Ribble Valley Borough Council
Housing & Development Control

Application no: **3/2022/0046**

Address: **42 Knowsley Road Wilpshire BB1 9PN**

Proposal: **Variation of condition 2 of planning permission 3/2021/0555. Amended plans in relation to the conversion of the integral garage (retrospective).**

21.052.pl.01

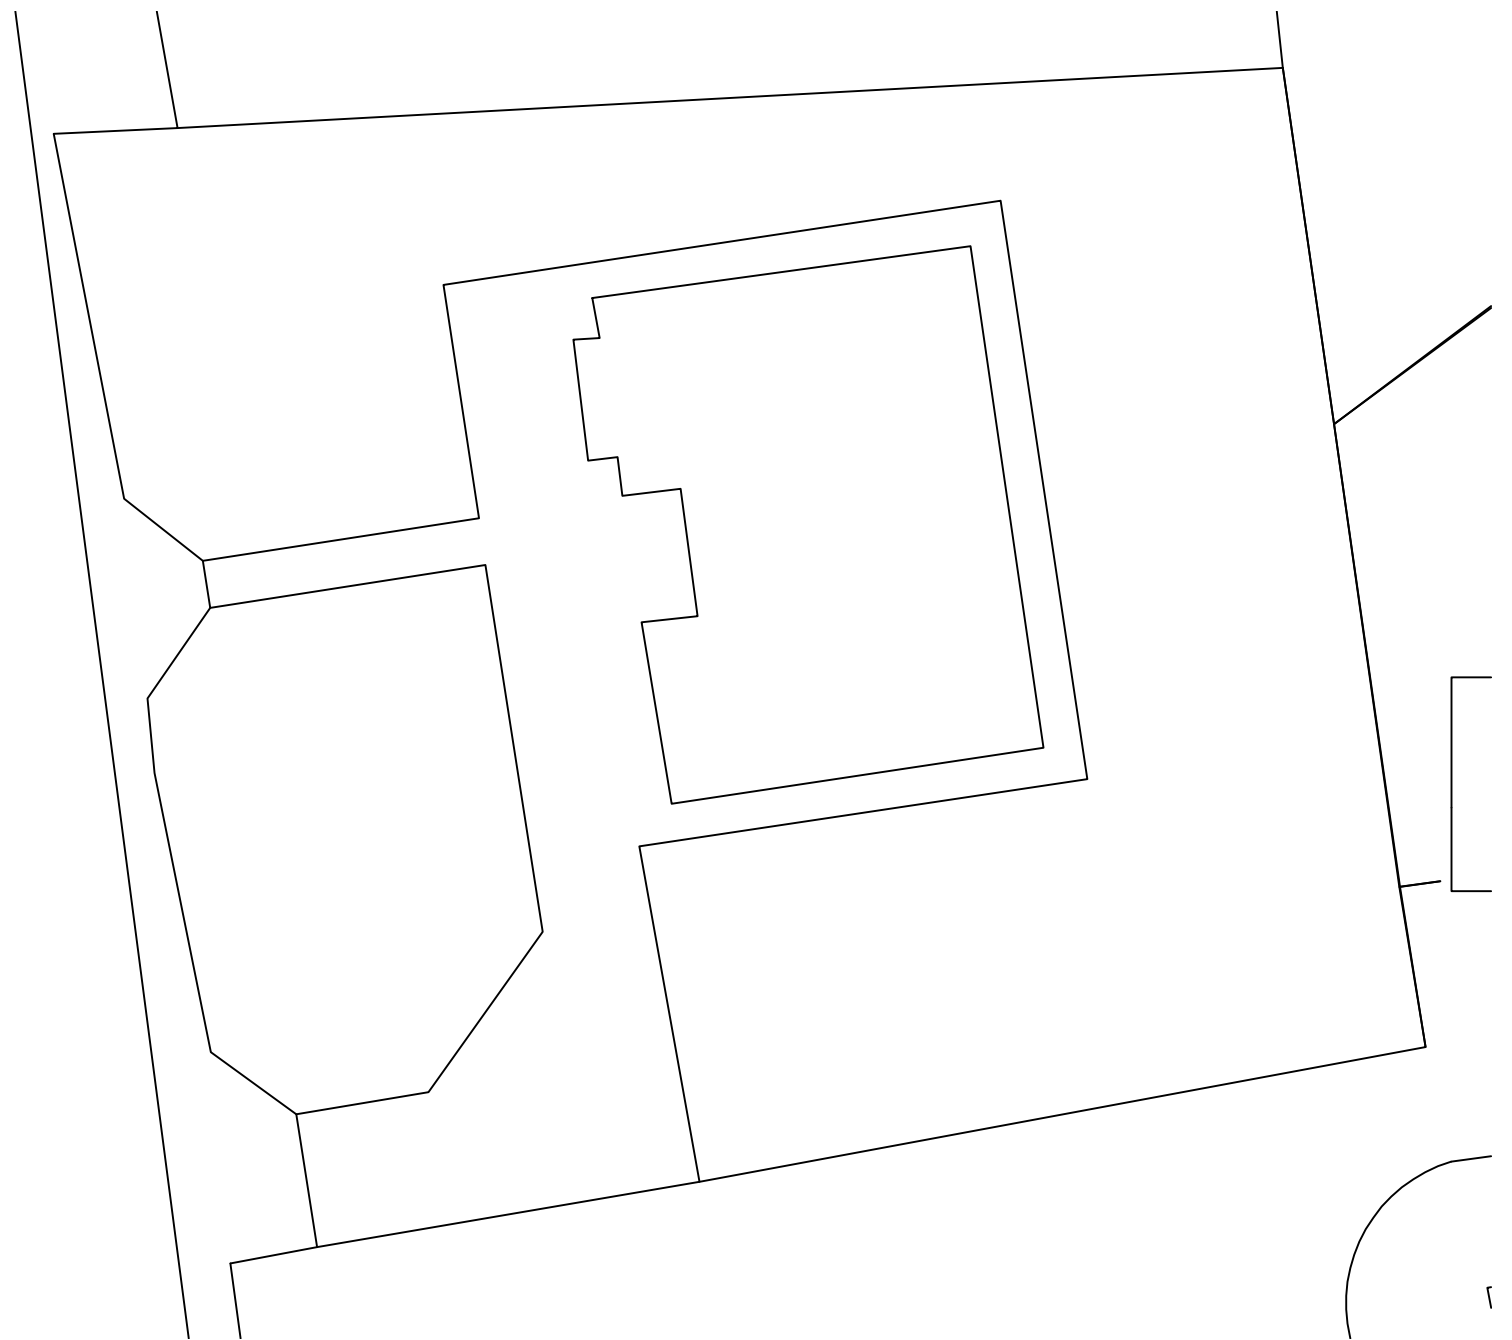
Notwithstanding this, the LHA have reviewed Swift Building Design drawing number 21.052.pl.01 titled "Location and Site Plans" and understands that 3 car parking spaces can still be provided at the site, on the existing driveway. Therefore, even without the garage, the site can still comply with the LHAs parking guidance found in the Joint Lancashire Structure Plan and so the LHA have no objection to the variation of condition.
